CITY OF ALBUQUERQUE

November 25, 2014

**Re: Lot 24 Rancho Guadalupe Subdivision
Grading and Drainage Plan
Engineer's Date 11-21-14 (F13D002C)**

GRADING AND DRAINAGE PLAN

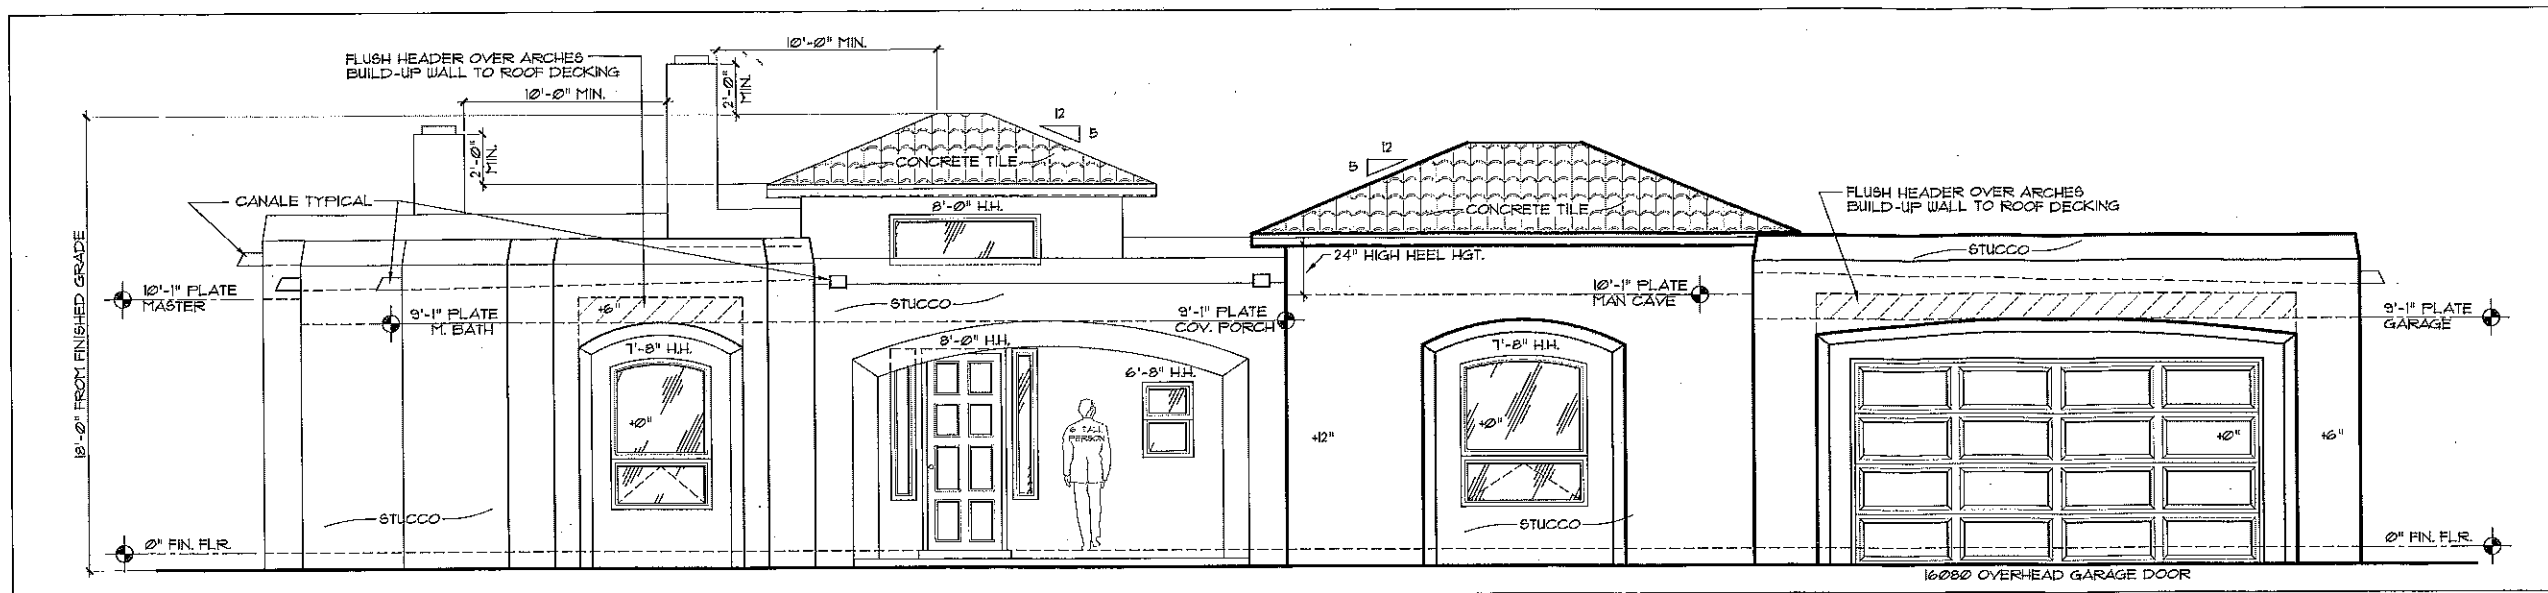
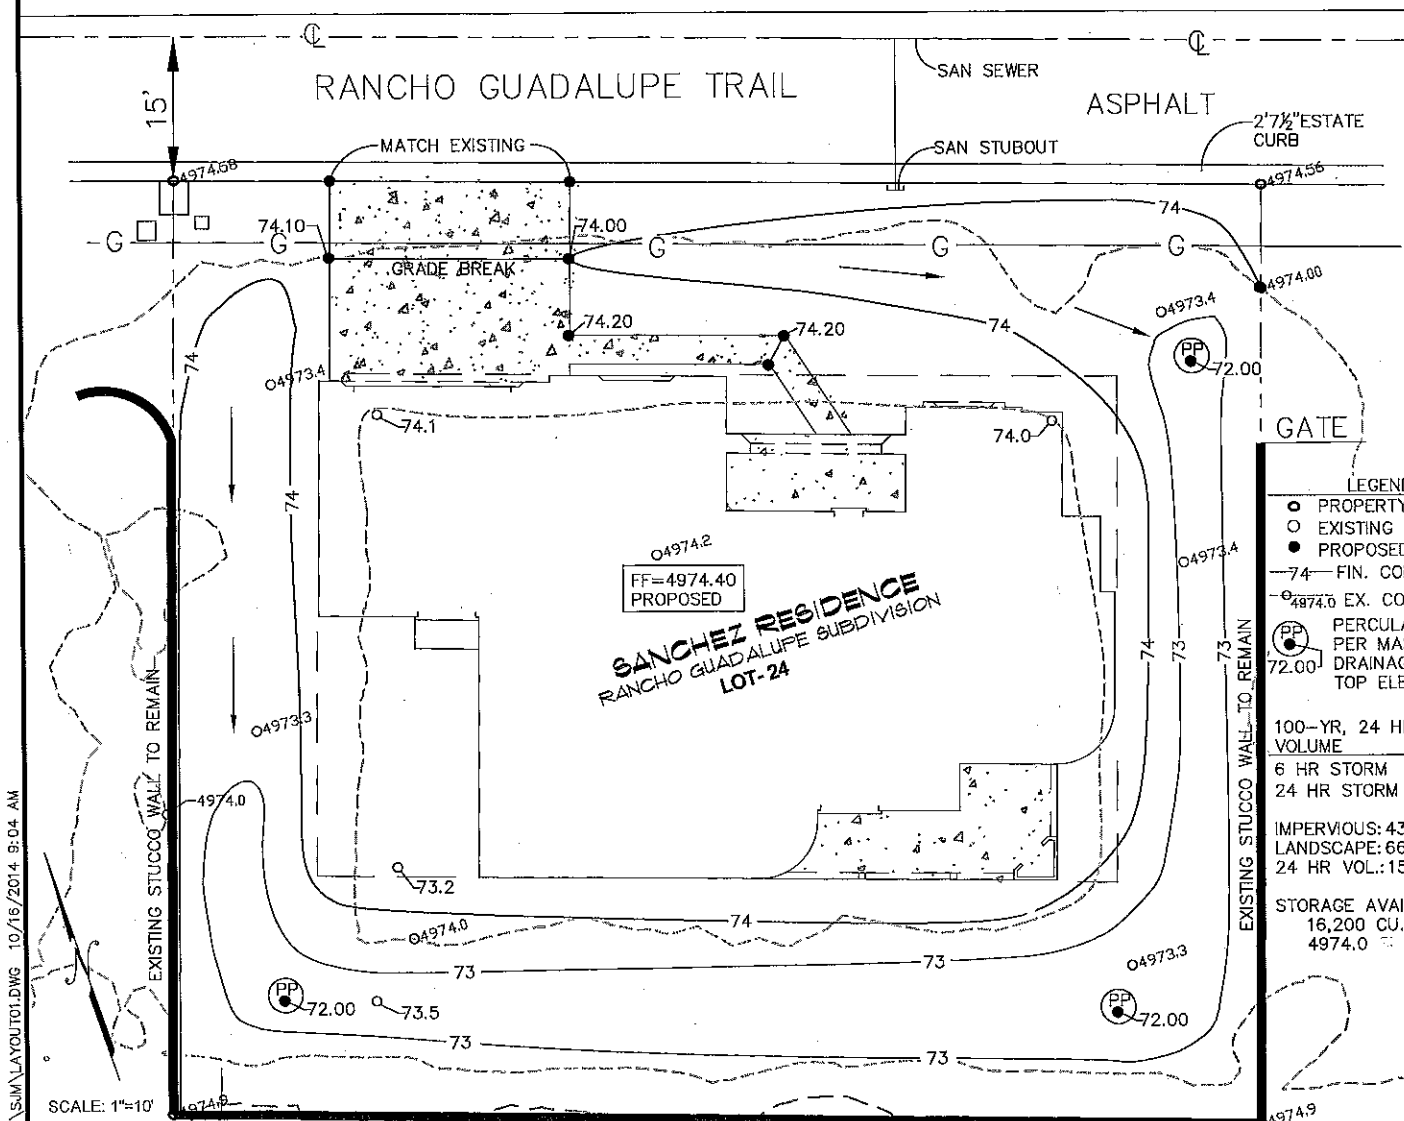
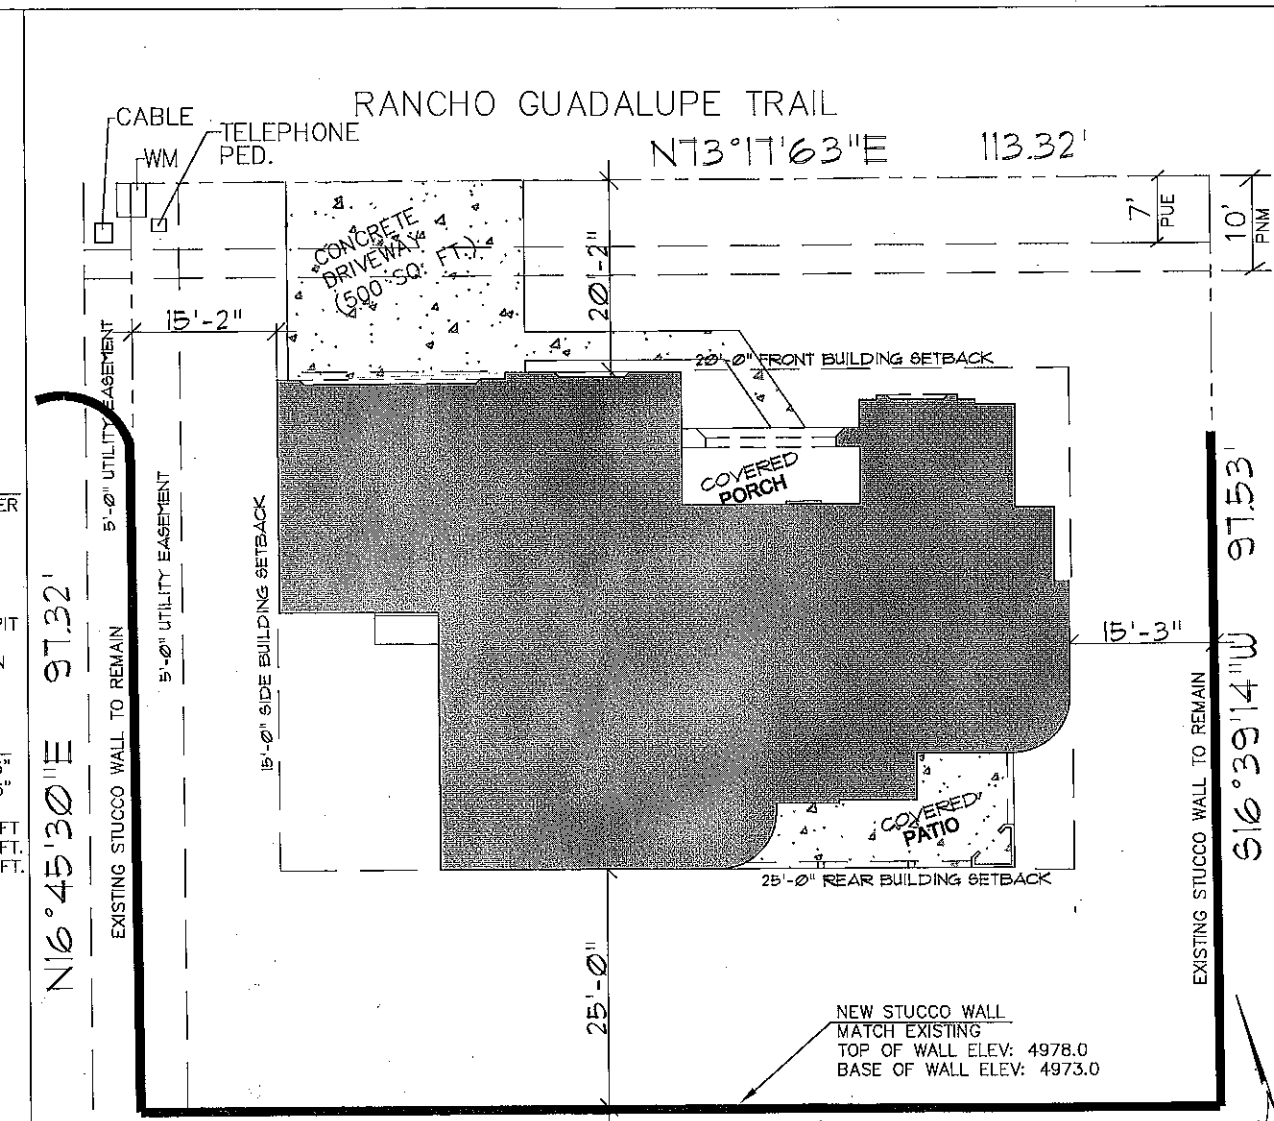
The correct First Flush amount is 0.34 times the impervious area of the site (4380 sf) which totals to 924 cf not 314 cf as stated on the plans. The ponding area is more than adequate for this. Please note this for future submittals to Hydrology.
